Parks and Wildlife

June 05, 2017

El Paso County: Development Services Department
ATTN: Kari Parsons, Project Manager
2880 International Circle Suite 110
Colorado Springs, CO
Re: SP-17-002 - Meadowbrook Crossing Preliminary Plan

MEADOWBROOK CROSSING
LOWER EAST FORK SAND CREEK PLAN AND PROFILE
STA. 9+00 TO STA. 21+00
EL PASO COUNTY, COLORADO

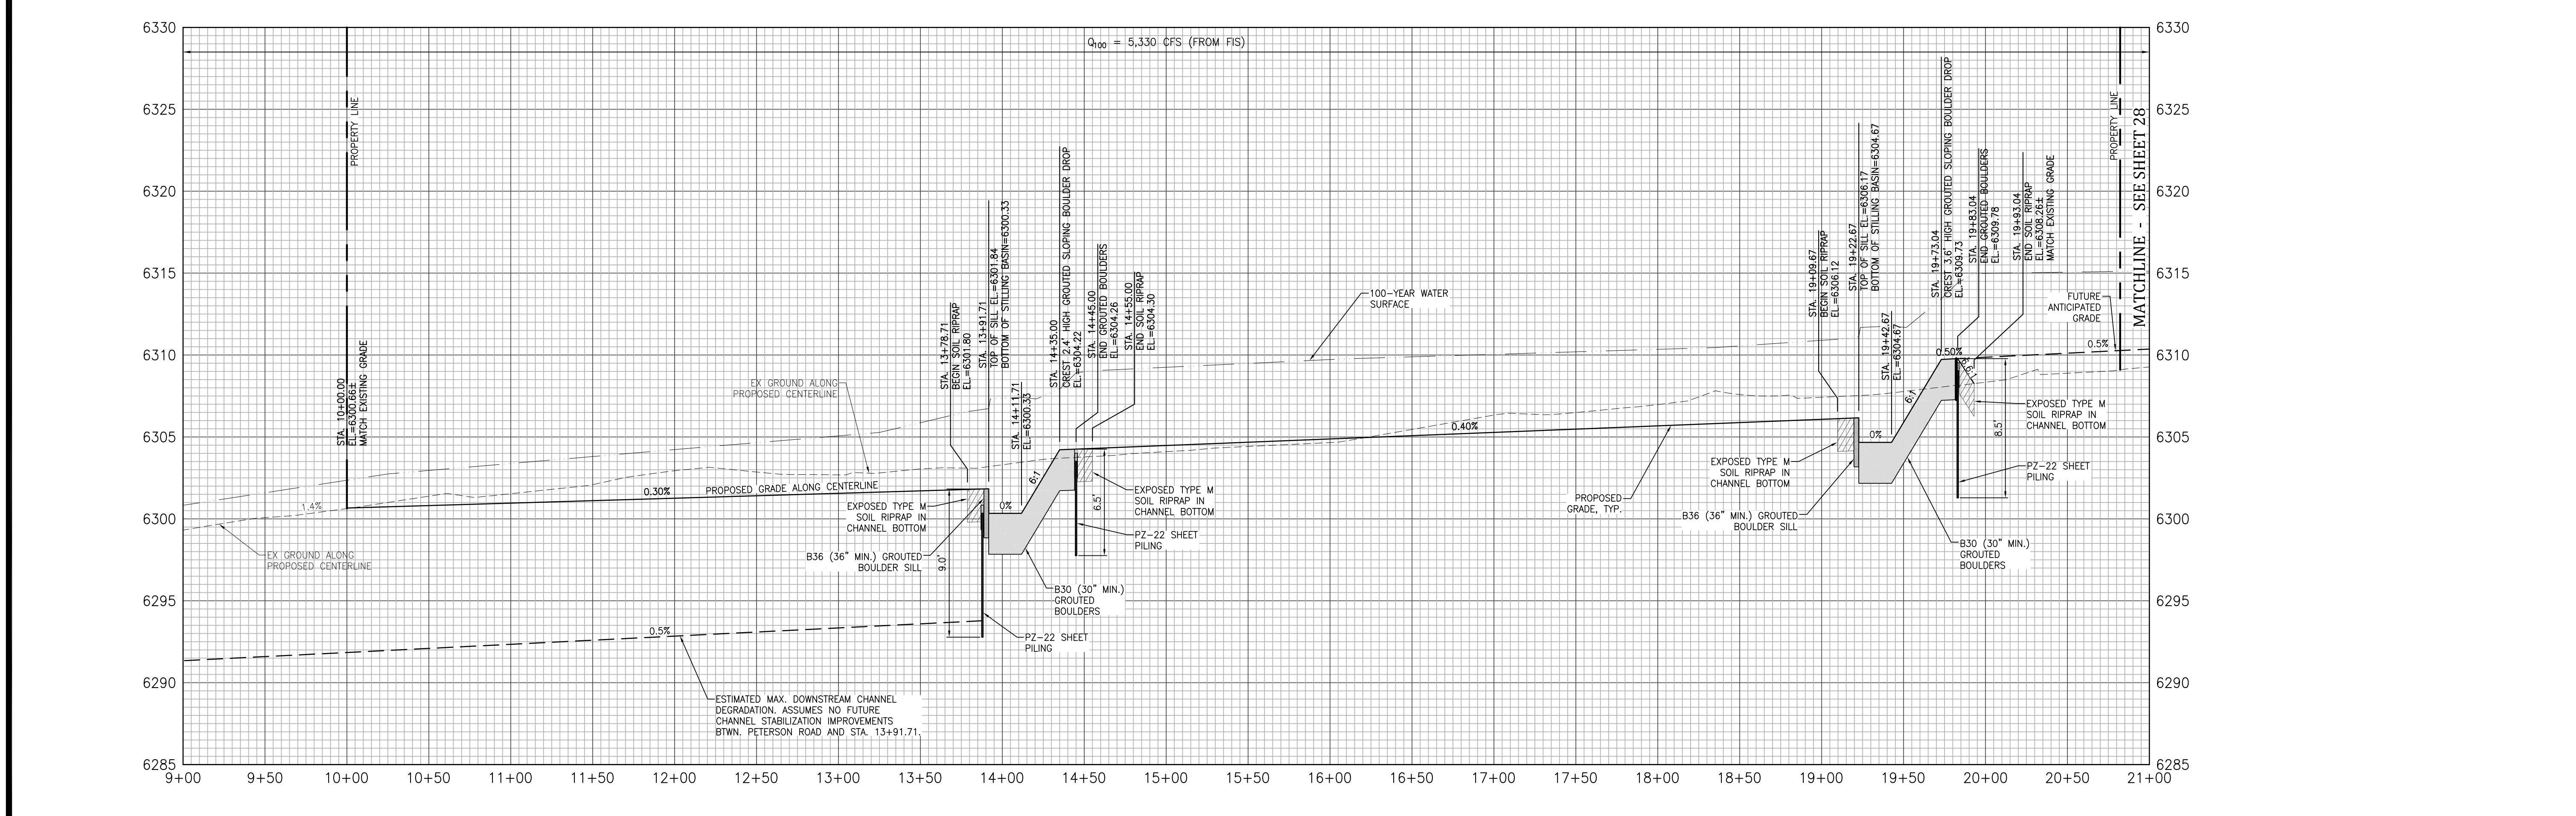
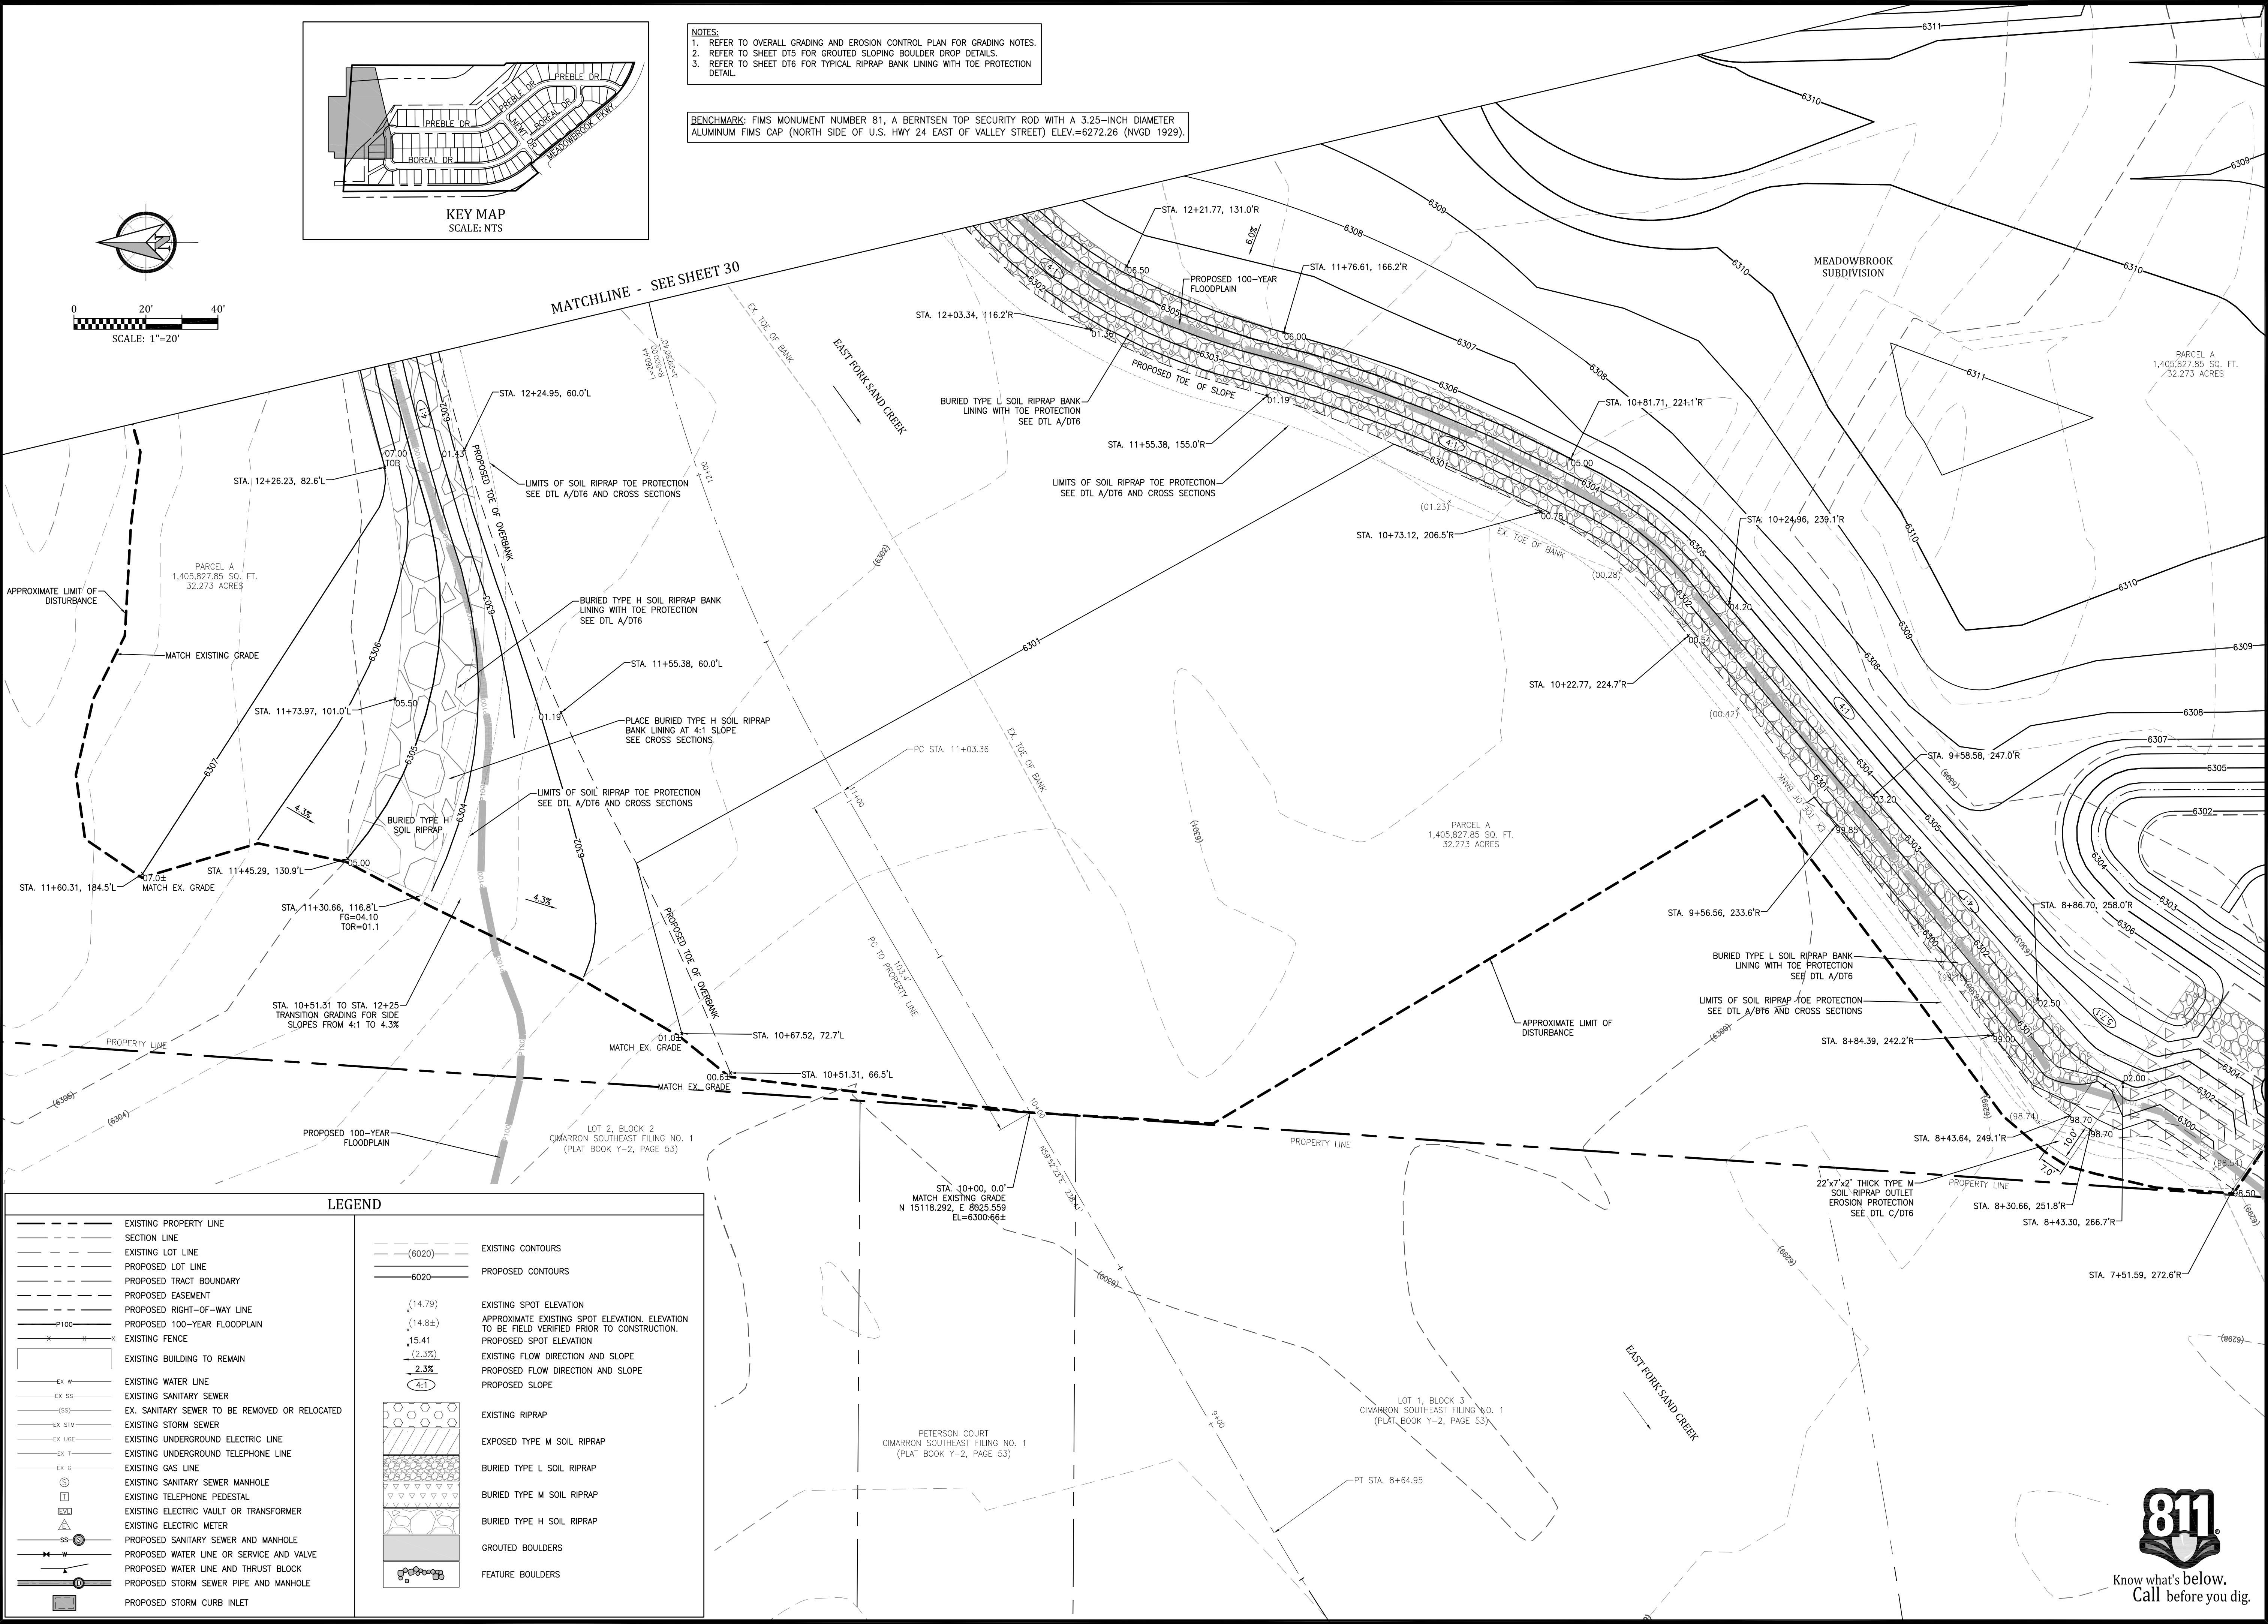
CPW does have some concerns about the continued channelization of Sand Creek in this area. The reports mentions the preservation of Sand Creek within the project area but also states the creek will undergo channel alignment to route it through the property and contain the 100 year flow to open additional land currently within the floodplan to development. The LOMR submitted for the project includes significant changes to stream banks, rerouting of the stream bed, drop locations and grouted boulders. The applicant also identifies areas of vegetation and existing trees on the northeast of the site but acknowledges that channelization project will be prioritized over retaining those trees.

Reduction in sinuosity (the way a stream channel bends) can cause negative impacts to the riparian wildlife habitat associated with this stream. As streams are straightened, the slope of the channel tends to steepen, thus increasing water flows and sedimentation. Riparian areas and flood plains slow flood waters, provide habitat for wildlife, and decreases potential damage to any structures that end up being built near the creek channel. A stream with higher sinuosity allows for willows and other plants to establish along the banks and create a complex root system, thus strengthening the integrity of the stream channel. Along the East Fork of Sand Creek the channel has undergone significant changes and much of that sinuosity has been lost. The channel is perfectly “U” shaped which further increases water velocity during high flow/flood events. In addition, large acreages of short grass prairie have been

developed creating a large amount of impervious surface. This increase in impervious surface combined with the new straightened and channelized nature of the creek will increase erosion, siltation and water velocity during heavy rain events which could have a negative impact on the surrounding environment as well as manmade structures. A flow pattern dominated by flood pulse events that is sharply amplified by the already constructed developments both up stream and down from the development's future location. CPW is concerned about the possible addition to the amplitude of flows that could result from the impacts listed above.

CPW recommends maintaining the stream channel in its natural sinuosity and maintaining connection to the riparian/flood plain. We recommend planting cottonwood trees and other riparian vegetation to offset erosion impacts and to mitigate for habitat loss. CPW recommends not using grouted rip-rap in the straight courses of the stream channel, as this tends to further increase stream flow rates. As mentioned above, this can have impacts to riparian habitats downstream. One alternative is to create random breaks and contoured grooves in the stream bed itself, thereby reducing and deflecting high stream flows. A design that creating a narrow, low water level channel along the bottom is preferable to a large, flat stream bed with rip-rap. If these stream improvements cannot be made in this project area, CPW recommends habitat improvements be made further downstream, in a less disturbed site. CPW recommends that storm water detention ponds be constructed deep enough to hold runoff from a sizable storm event so that flows need not be conveyed to Sand Creek. If that is not possible then we recommend that these flows are controlled and slowly released or are conveyed off-site. Both release into Sand Creek and off-site conveyance are included in the application and clarification of the final plans should be provided by the applicant.

Soil Rating Lines

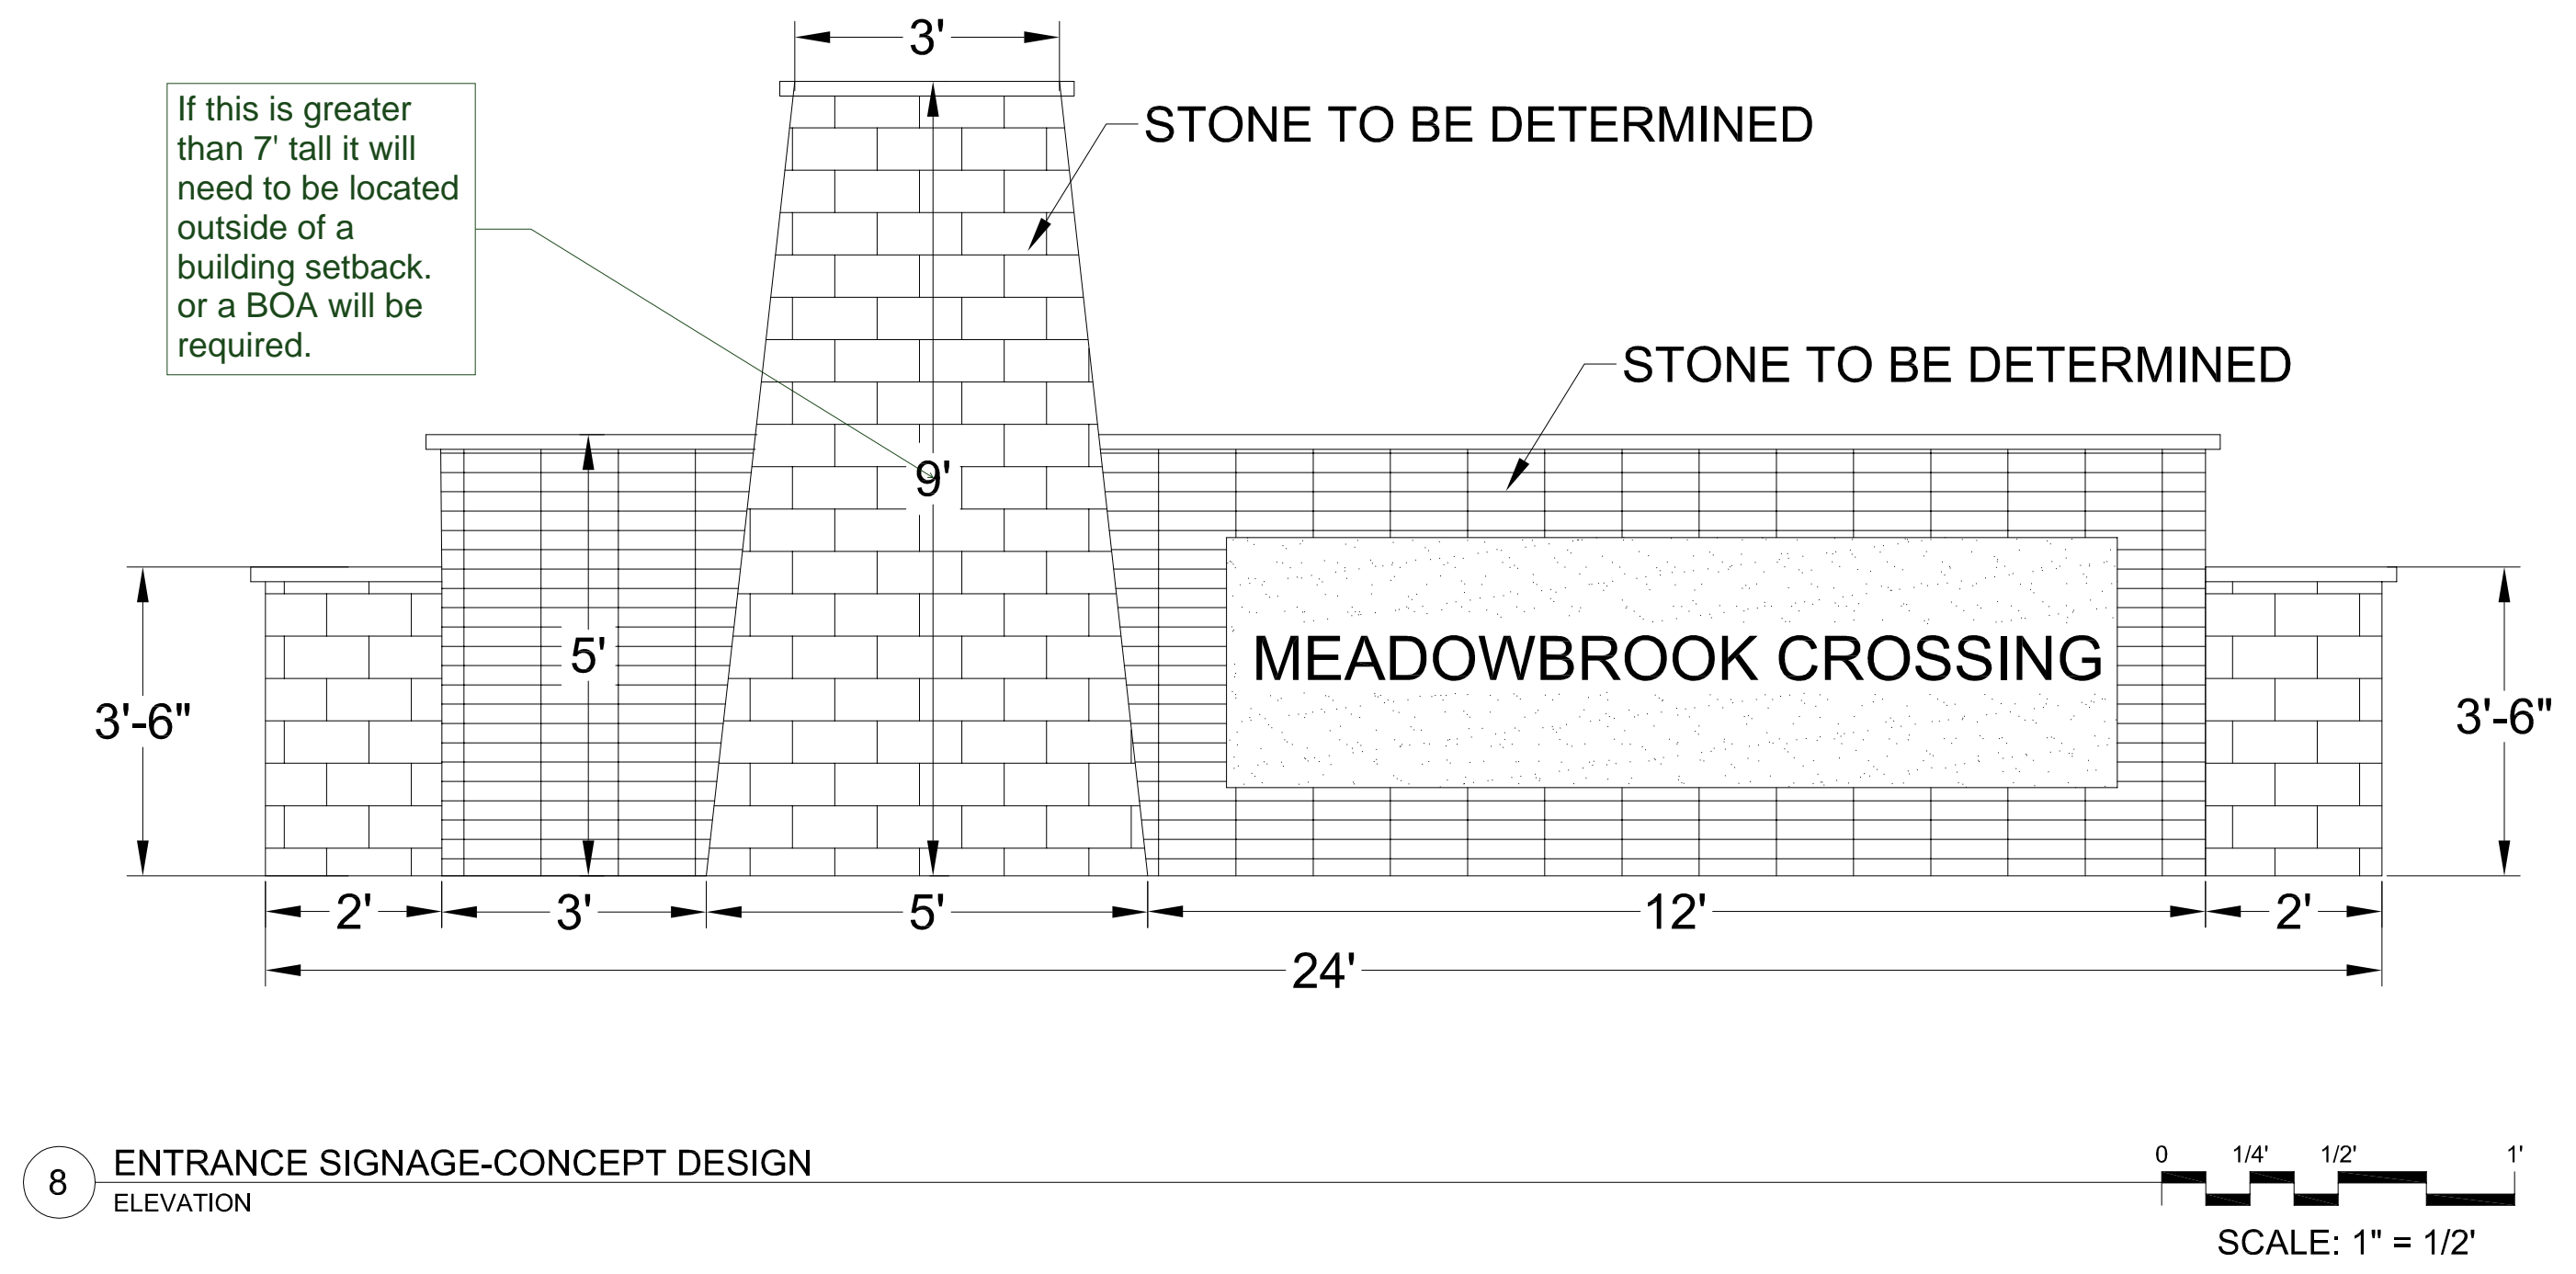
Fences can cause many problems for wildlife, including death, entanglements, and barriers to movements. CPW recommends the developers consult our publication *Hanophy, Wendy* "Fencing with Wildlife in mind." *CPW.state.co.us. 2009* when considering the design of fences within the development. The publication is available on our website at <http://cpw.state.co.us/Documents/LandWater/PrivateLandPrograms/FencingWithWildlifeInMind.pdf> . The use of privacy fencing, chain link fencing, and other exclusionary fencing should be at least 6 feet high and should be restricted to the immediate area surrounding the buildings or within the designated building envelope and should not be used as a method to designate boundaries of larger lot sizes (> 1 acre). Fencing outside the immediate building envelope or area surrounding the buildings on larger lots within the known range of elk, deer and pronghorn should be a maximum top height of 42" with at least 12" spacing between the top two wires or rails and a bottom wire or rail at least 16" above the ground to allow passage of juvenile animals and pronghorn antelope. It is also recommended that the top and bottom wires be a twisted barbless type or smooth wire or rail construction. Construction of ornamental wrought iron fencing with closely spaced vertical bars (<12") and sharp projections extending beyond the top horizontal bar should be strongly discouraged in areas where deer, elk, and black bear are known to occur. This type of fencing typically ensnares deer and elk by the hips when trying to squeeze through and impales animals attempting to

6. Fences, other than those around the immediate domicile and serving to protect landscaped trees and shrubs, should be designed so as not to impair wildlife movements. Ornamental fences with sharp vertical points or projections extending beyond the top rail should be strongly discouraged. Wildlife friendly design recommendations can be provided upon request.
